Henry Adams
Rowan House
Baffins Lane
Chichester
PO19 1UA

Please ask for: Ms Iqraa Malik
Email: iqraa.malik@terraquest.co.uk
Telephone: 0121 234 1390
Our Ref: AB/38/22/HH
Your Ref:
Date: 11th April 2022

Application for Planning Permission for Works or Extension to a Dwelling

Development: Retrospective application for the construction of a summerhouse to the rear of the host dwelling
Location: 114 Fitzalan Road Arundel BN18 9JY

Proposed Floor Plan 1:50 @ A3

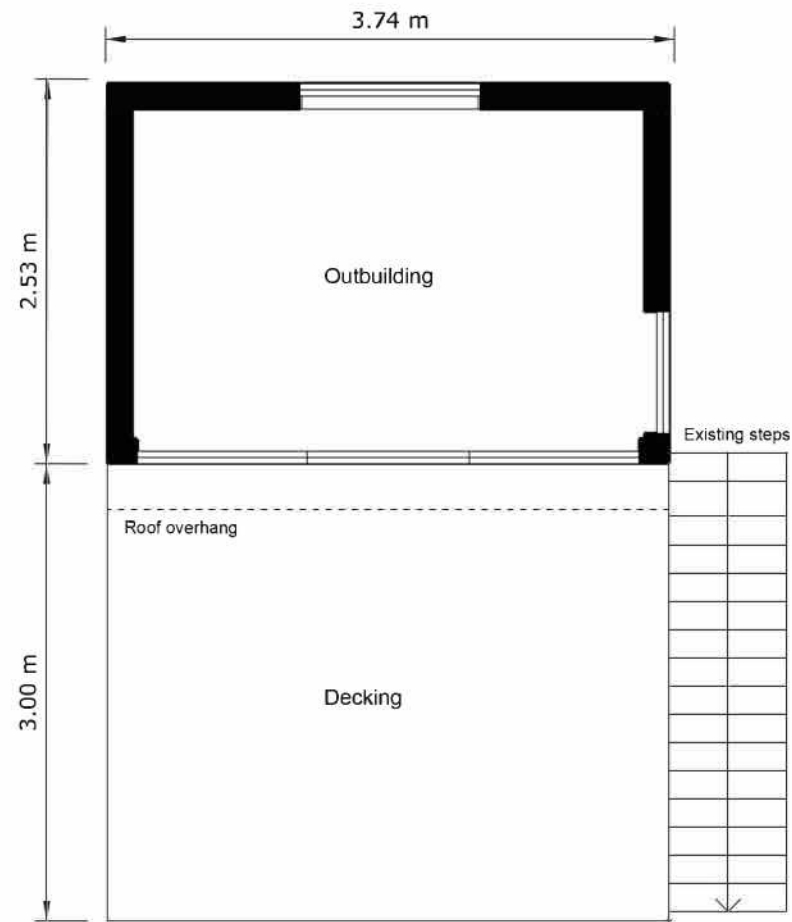
Floor Plan: The floor plan does not measure to the stated scale. Please amend.

Block Plan 1:500 @ A1

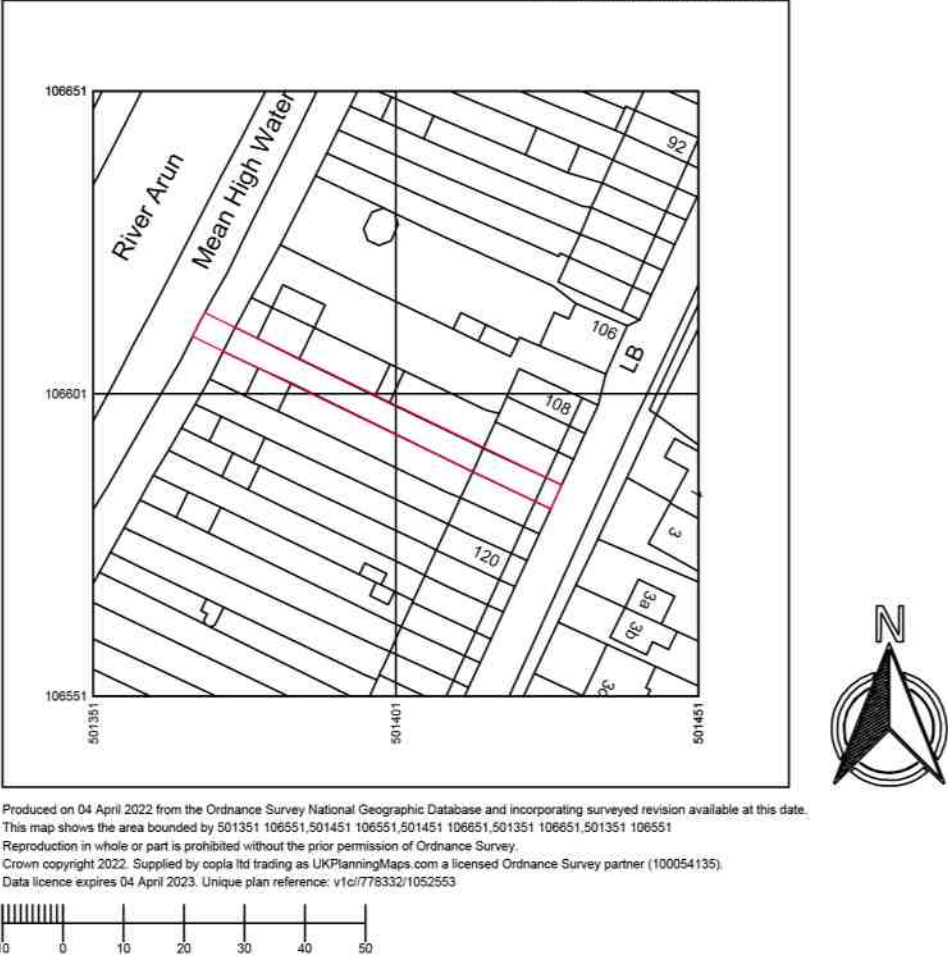
Dimensions: You are required to include dimensions on the block plan from the proposed site to all site boundaries.

Dimensions: You are required to include dimensions on the block plan from the proposed site to all site boundaries.
